29 May 2013

Ref 12135

**MODIFICATIONS OF PREVIOUSLY APPROVED MIXED USE DEVELOPMENT
23-37 LINDFIELD AVENUE & 11 HAVILAH LANE, LINDFIELD
TRAFFIC AND PARKING MATTERS**

Drawing Title
BASEMENT 3 PLAN

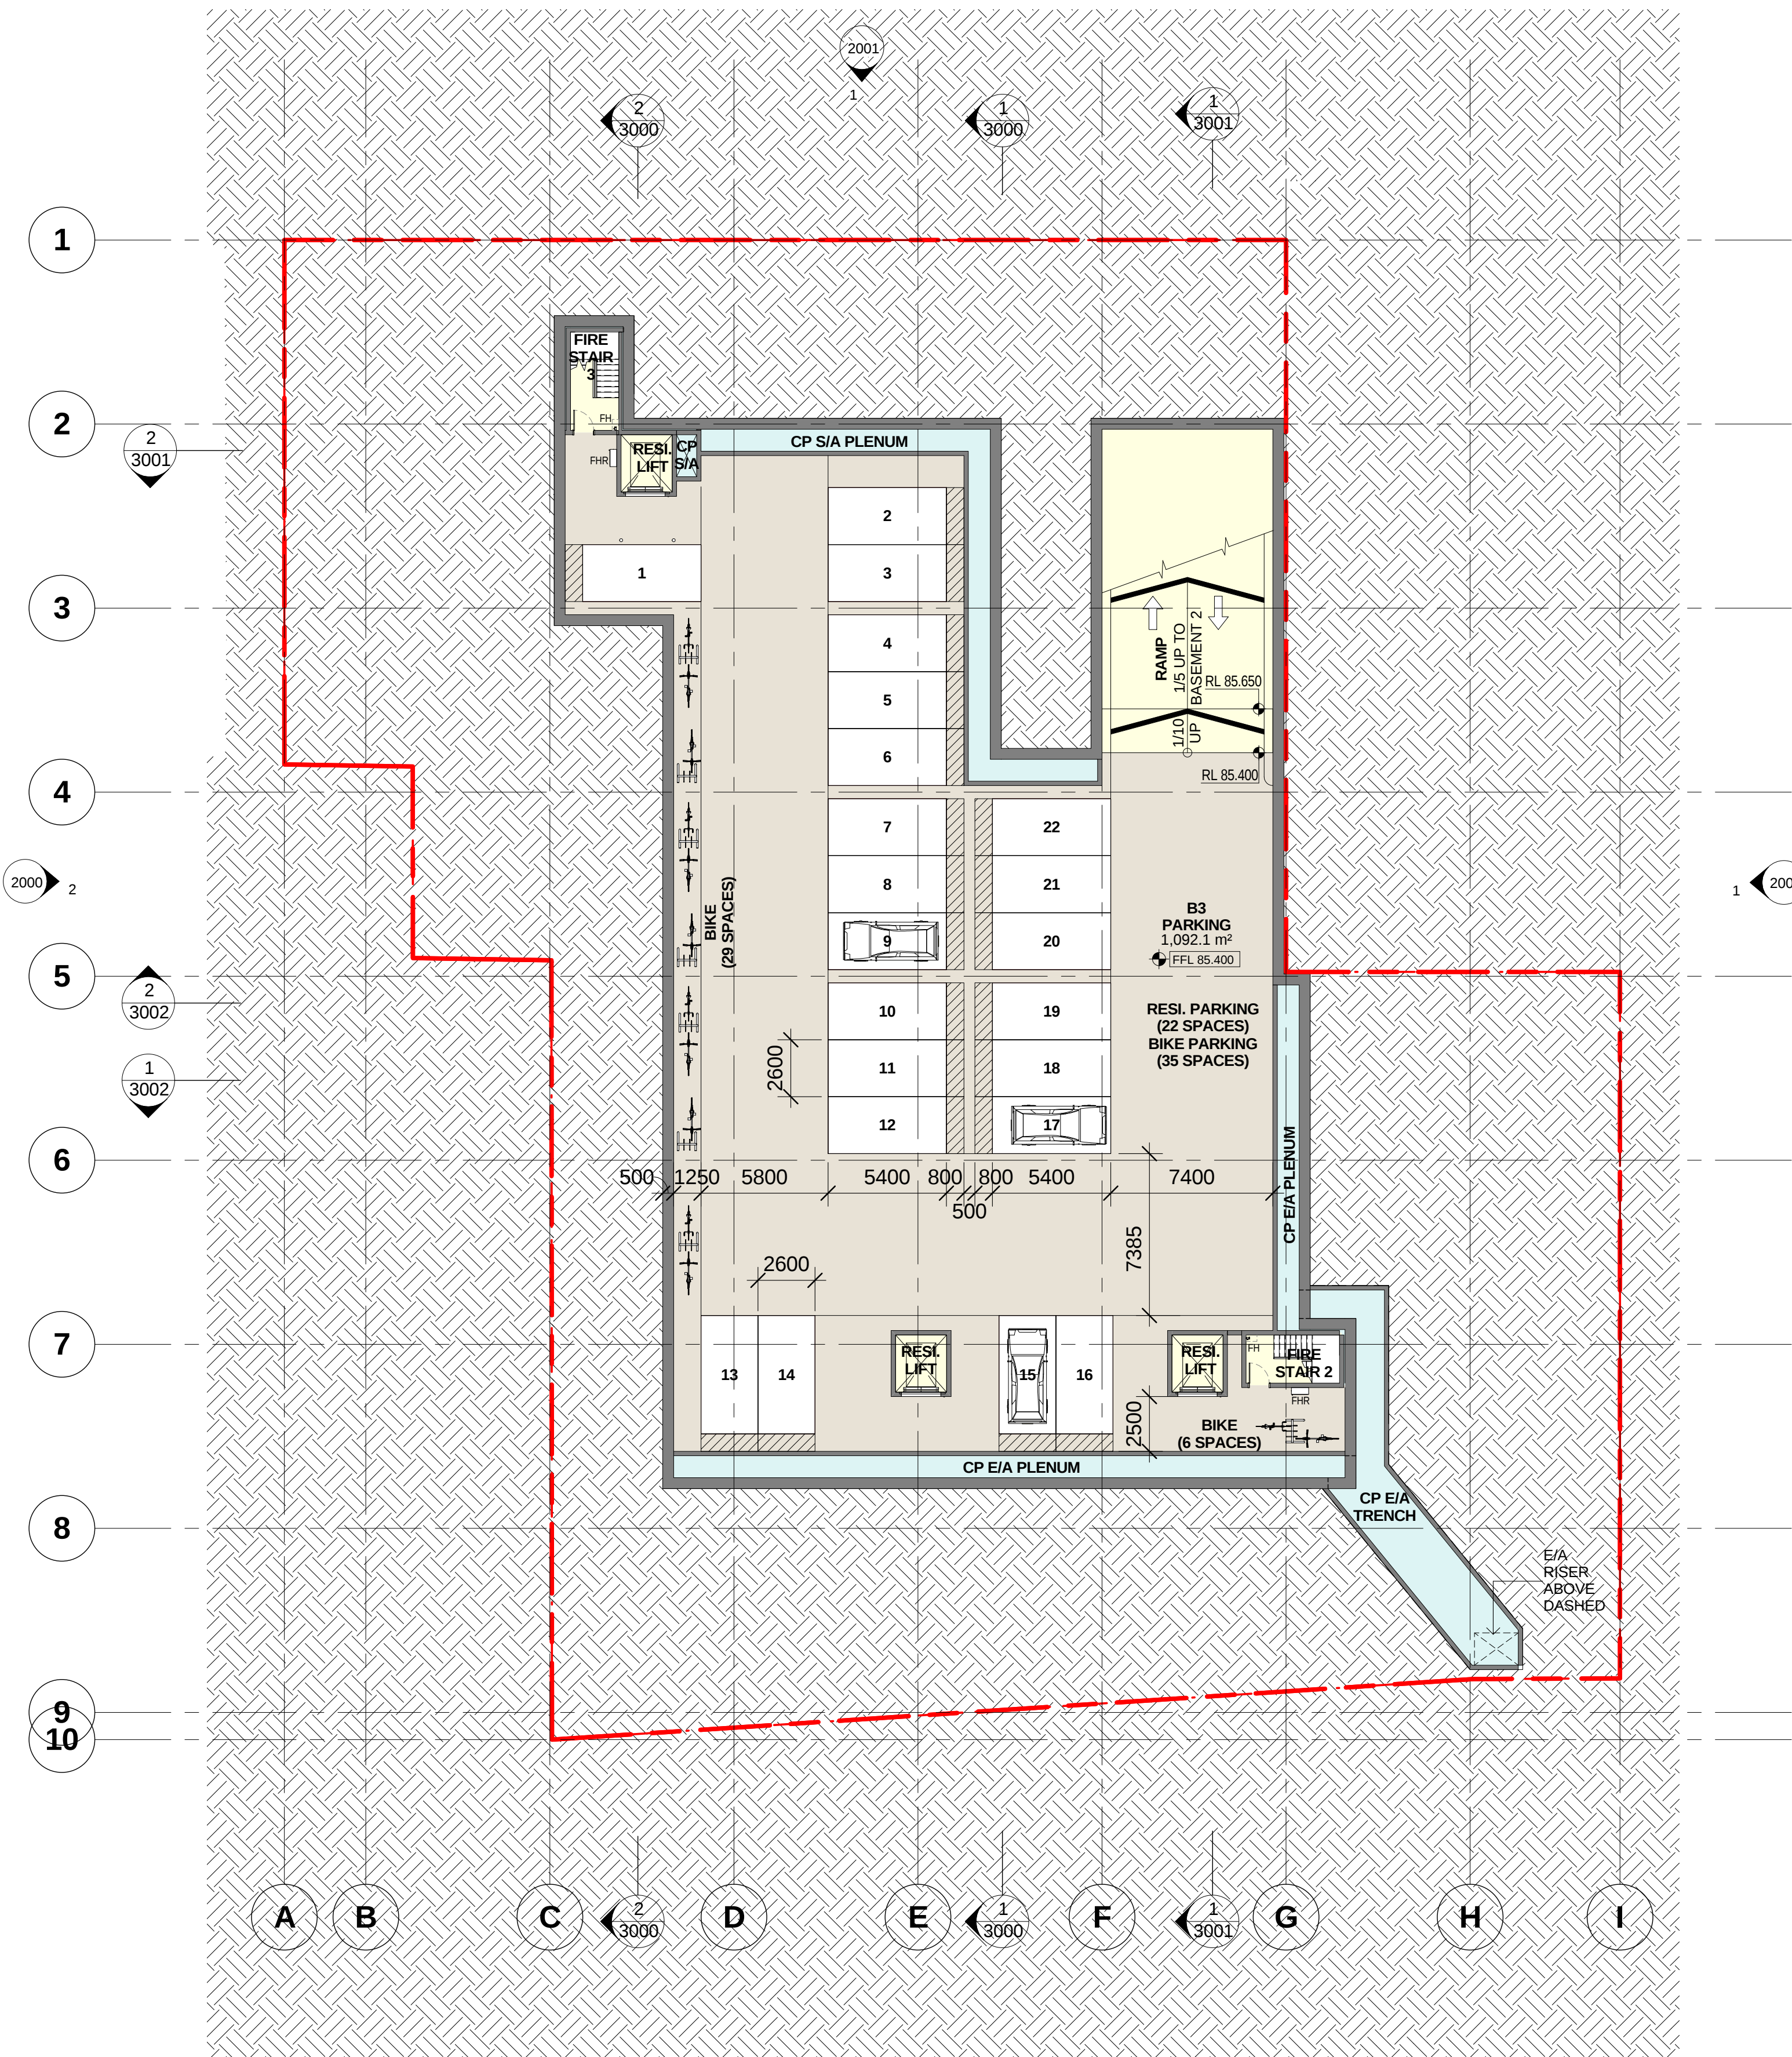
- revised basement carparking plans have been prepared incorporating an additional basement level of carparking, as requested. All aspects of the proposed vehicular access and carparking arrangements have been designed to comply with the Standards Australia publication *Parking Facilities Part 1: Off-Street Car Parking AS2890.1 – 2004*. In particular, it is noted that the retail parking level has been designed with wider aisles and wider parking spaces nominated by *AS2890.1* for shopping centres. The additional widths are *above* the minimum single manoeuvre width required to facilitate easy access in/out of parking spaces and to enable for opening of all car doors, in accordance with the requirements of *Use Class 3A* for shopping centres

As noted in the foregoing, an additional level of basement carparking has now been incorporated in the development proposal, yielding a total of 184 off-street carparking spaces to be provided on the site. That proposed carparking provision does *not* include the 25 parking spaces located on the adjacent site. The increased parking to be provided on the site is to be allocated as set out in the table below:

Use		Number of Original S75W Spaces	Revised Number of Spaces Now Proposed
Residential Parking	(Basement 1, 2, 3)	106 spaces	118 spaces
Residential Visitor Parking	(Basement 1)	8 spaces	12 spaces
Retail Parking*	(Lower Ground Level)	42 spaces	44 spaces
Retail Staff Parking	(Basement 1)	6 spaces	10 spaces
Total Car Parking		162 spaces	184 spaces

Drawing Title
LOWER GROUND FLOOR PLAN

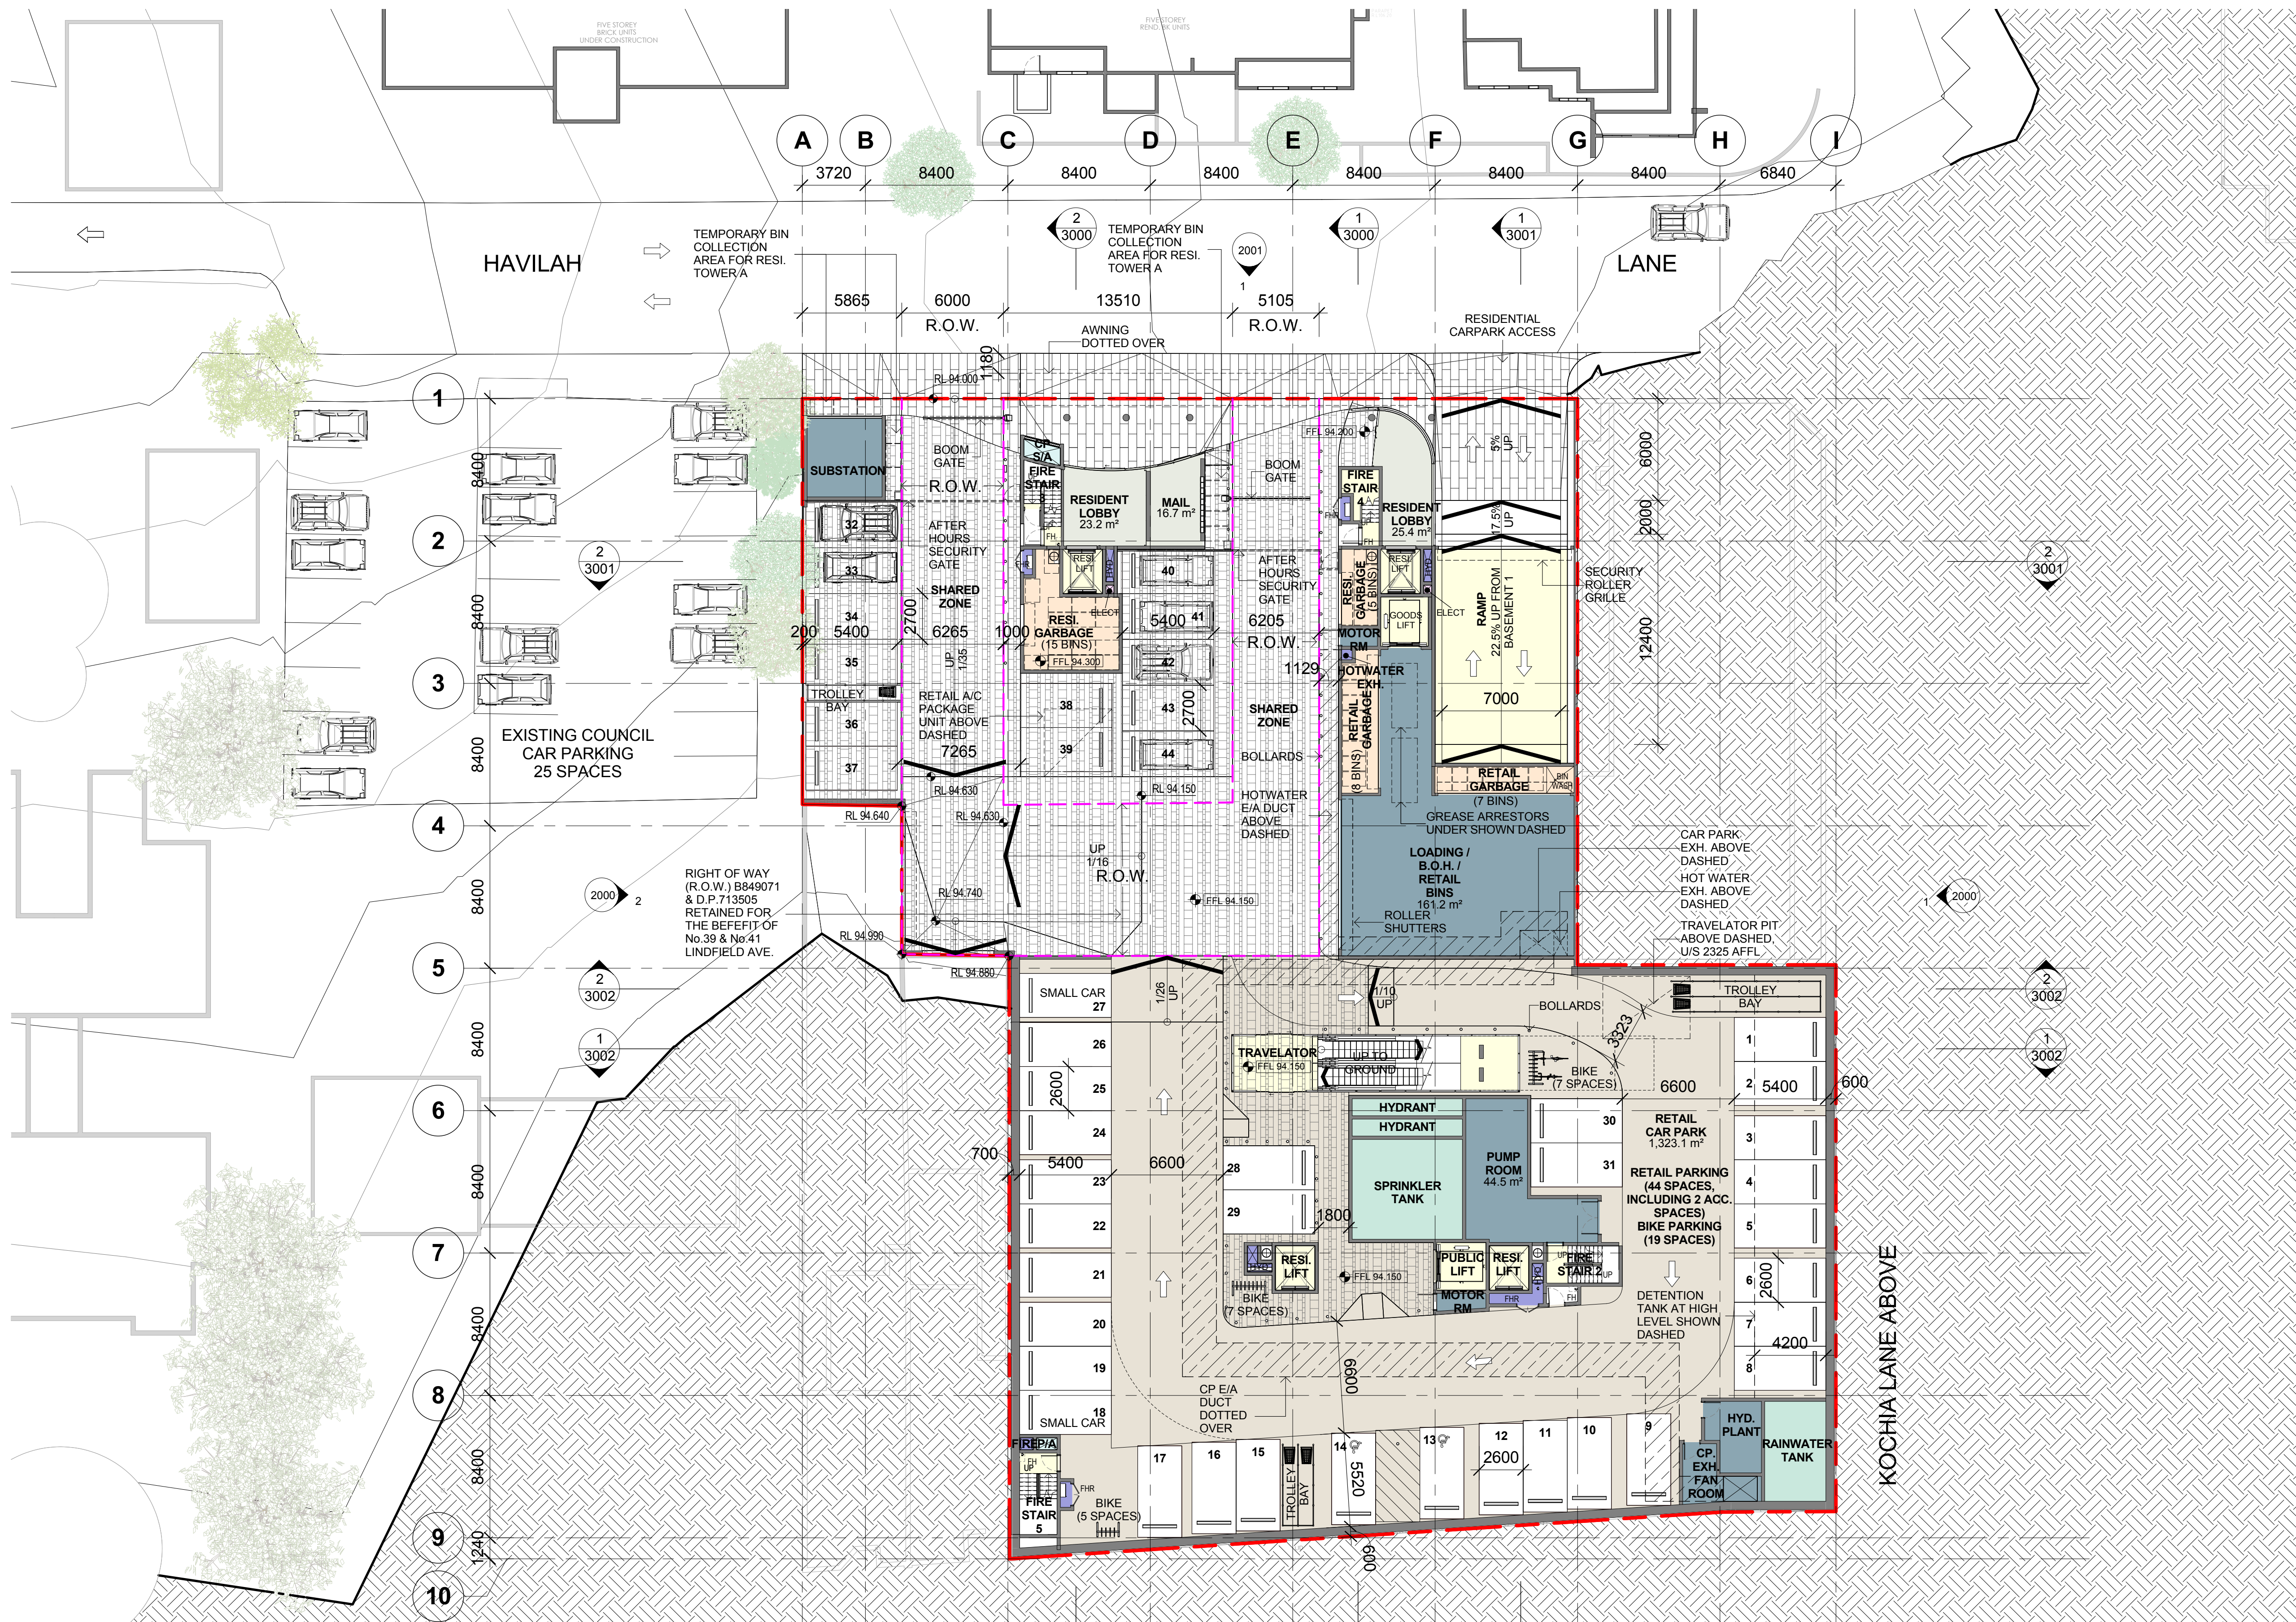
The Shared Zone proposed off Havilah Lane is to be managed with a Vehicle Management Plan as detailed in the attached documentation. A key feature of the Vehicle Management Plan will be the use of an *accredited* Traffic Controller whose task it will be to supervise the safe arrival and departure of all trucks accessing the loading dock.

In addition, whilst the area will operate as a Shared Zone, a separate, dedicated pedestrian path will be provided along the eastern side of the Shared Zone which will be separated from the adjacent Shared Zone by a row of bollards.

- swept path analysis* confirms that the proposed arrangements will be able to accommodate a large 11m long rigid truck whilst travelling in a forward direction at all times, as illustrated on the *Vehicle Access Plan* drawing number 6000 Revision B prepared by *Crone Partners*. The truck will reverse into the loading dock under the supervision of an *accredited* Traffic Controller. The generously proportioned vehicle manoeuvring area will ensure that trucks will be able to access the loading dock in a simple, single manoeuvre without causing any delays to other carpark users. In addition, the 9.5m width of the loading dock will be capable of accommodating at least 3 delivery vehicles simultaneously well in excess of likely needs, such that there will never be any need for delivery vehicles to obstruct vehicle circulation
